**PERSIMMON HOMES THAMES VALLEY
NORTH LITTLEHAMPTON
INTERNAL WORKS, PARCELS B2, B4 & C1
LITTLEHAMPTON, WEST SUSSEX**

**STAGE 1 - ROAD SAFETY AUDIT
ADDENDUM**

SEPTEMBER 2017

drawing number	A/PHLITTLE-INT.1/10-1	rev.	P4
----------------	-----------------------	------	----

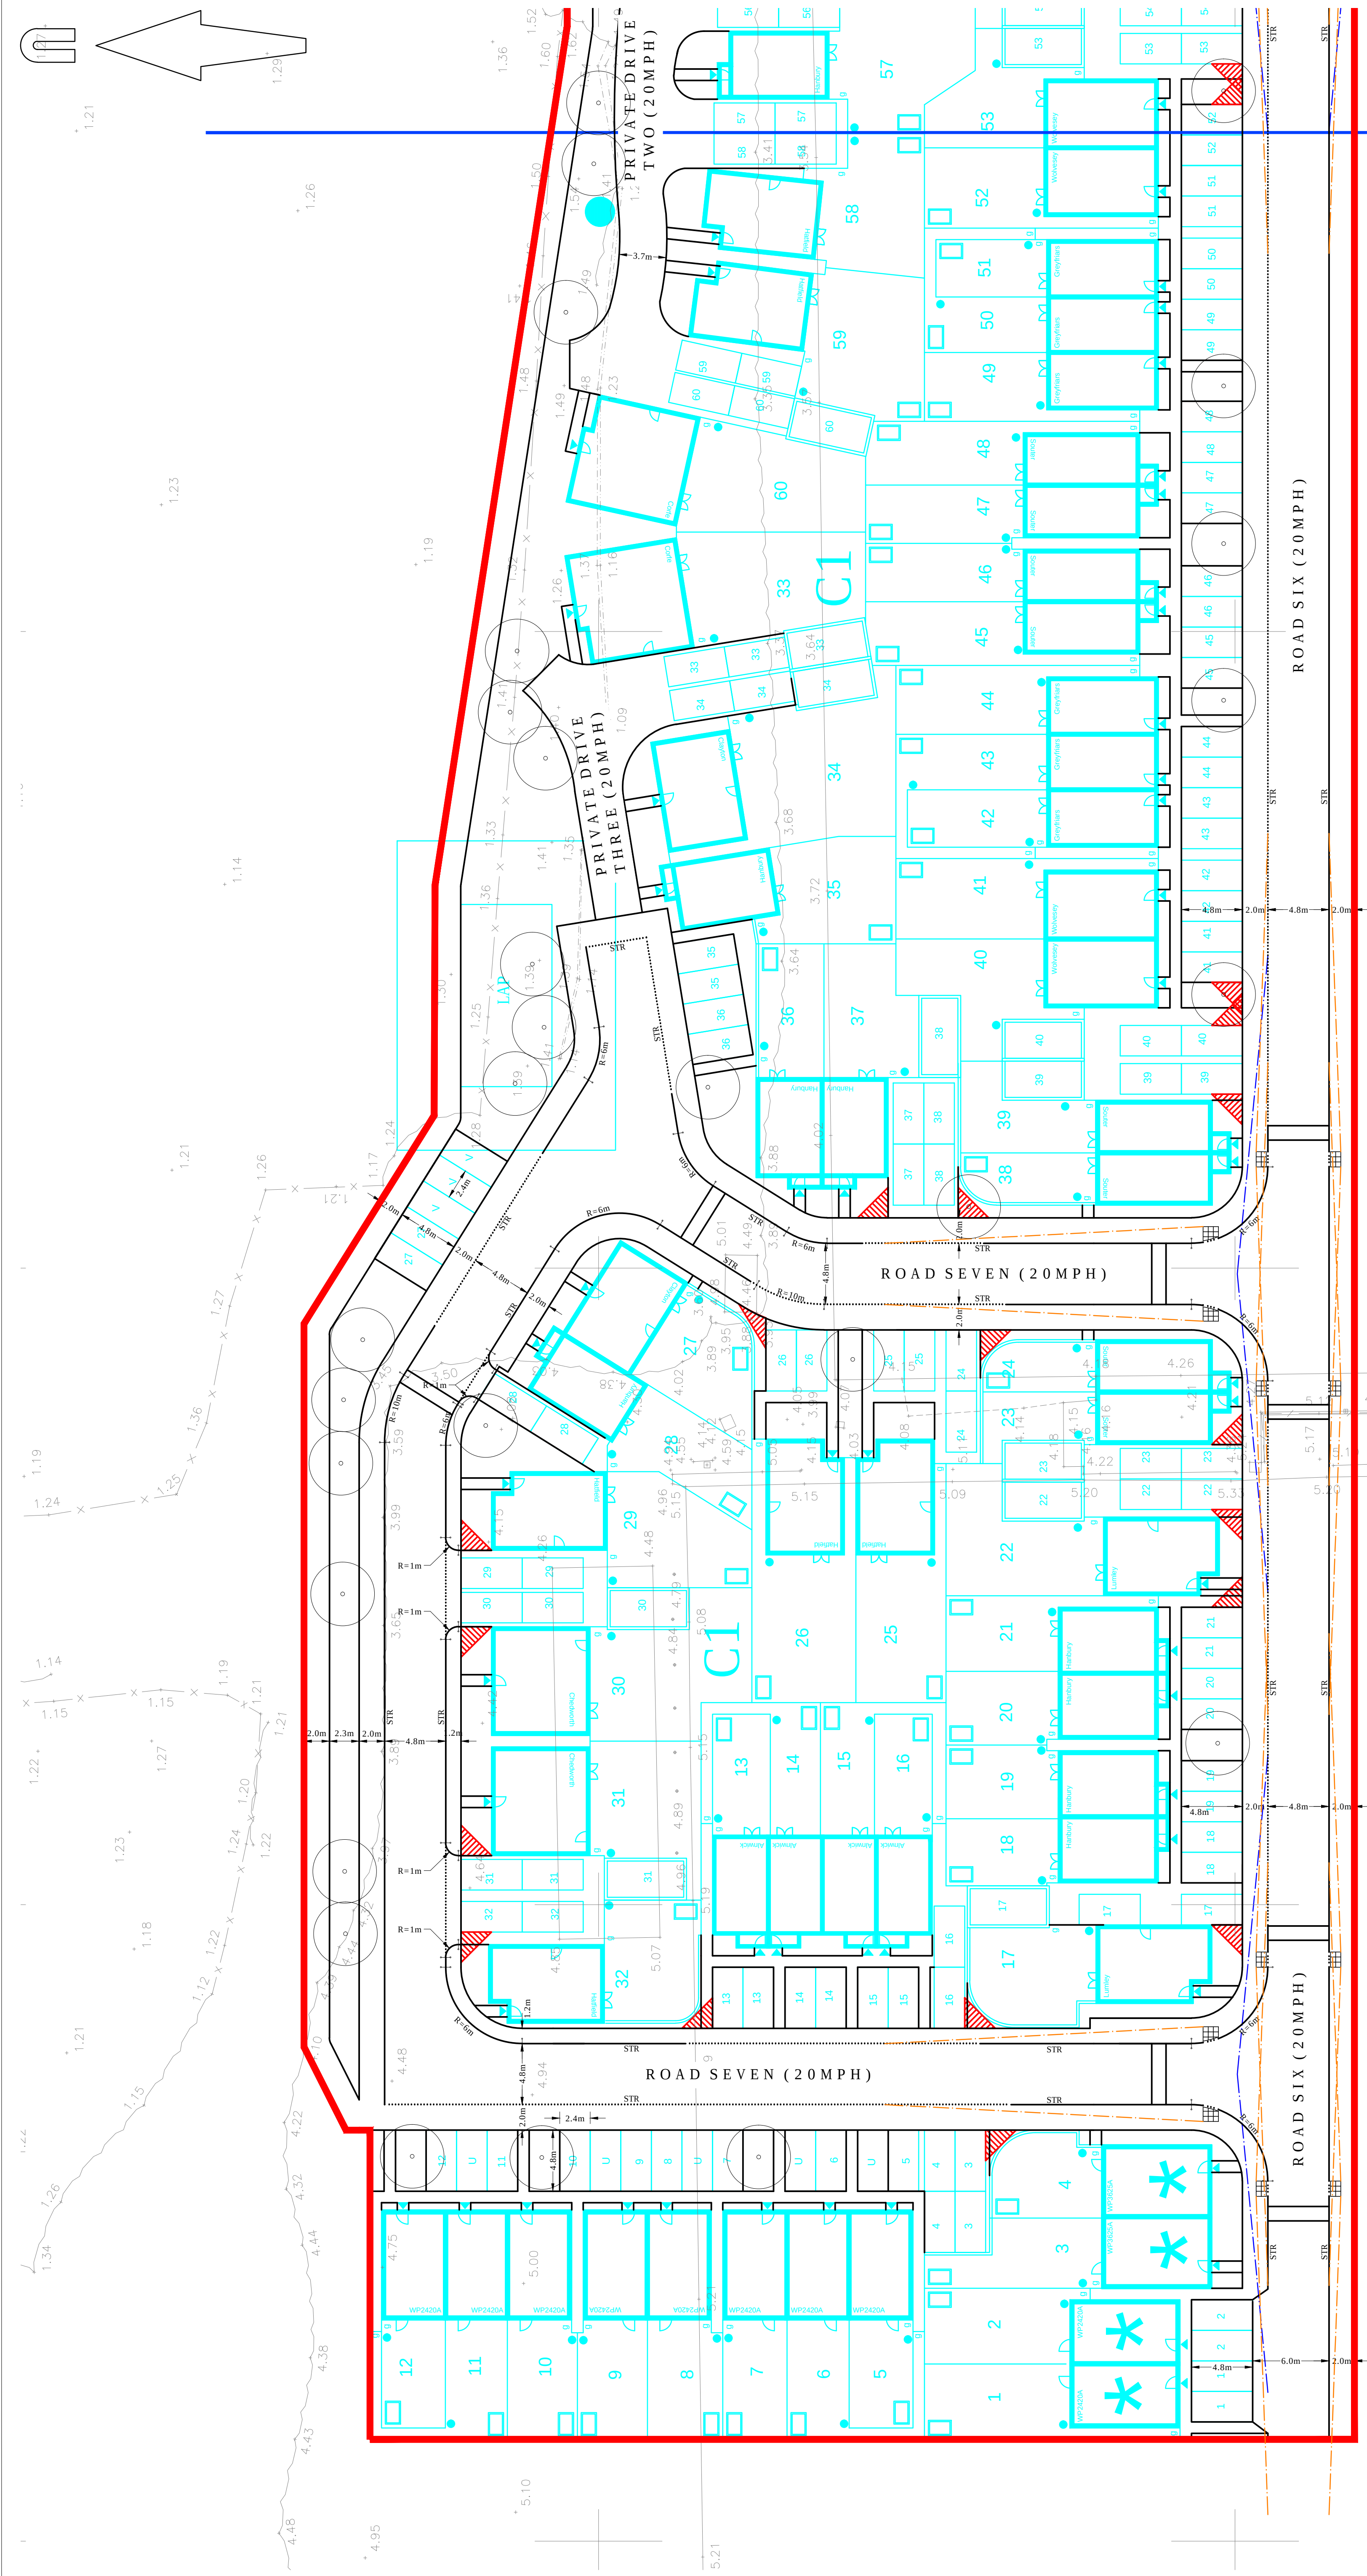
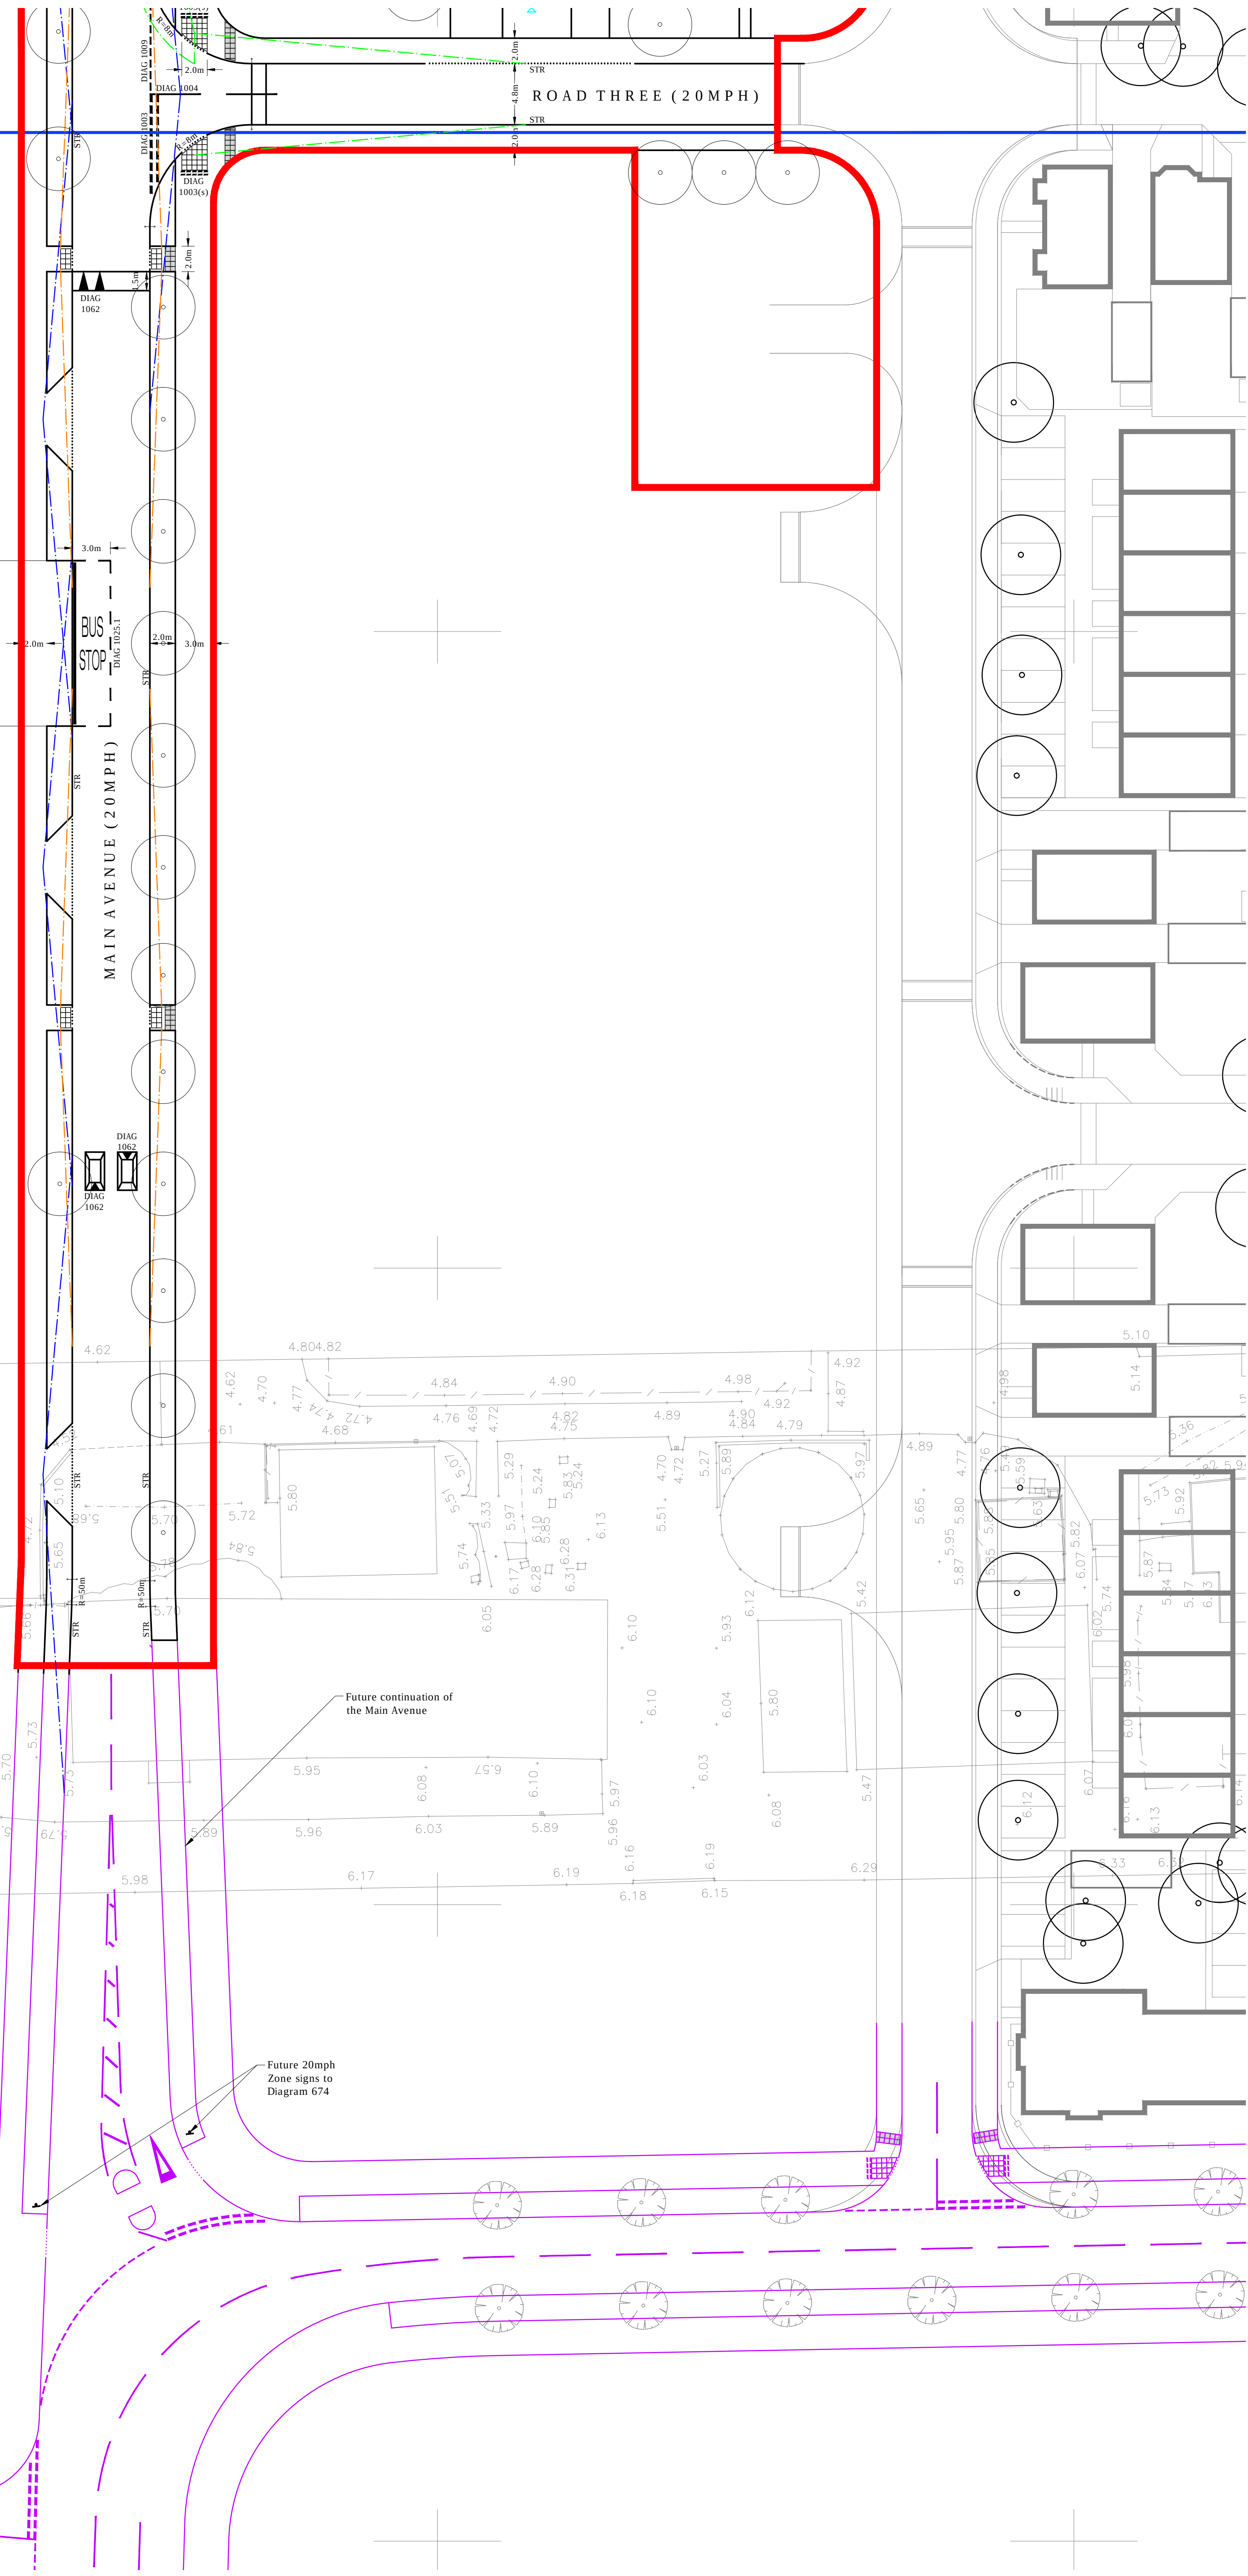
Whilst some visibility splays have been formally identified on the drawings submitted, it will be important that all visibility splays remain free from obstruction. It is noted that some visibility splays extend across / through 3rd party land, cycle storage areas or parking bays (on 3rd party land).

It will also be important to ensure that appropriate visibility splays are provided. It is noted that the visibility splays indicated on parts of Main Avenue are not suitable for a 30mph speed limit.

Provide visibility splays in accordance with relevant design standards and ensure that the splays will be kept free from obstruction. Any vegetation within the splays should be maintained to ensure that it does not extend beyond a vertical height of 0.6m. If planters are to be provided then these, together with any foliage which they contain, should also not extend beyond a vertical height of 0.6m.
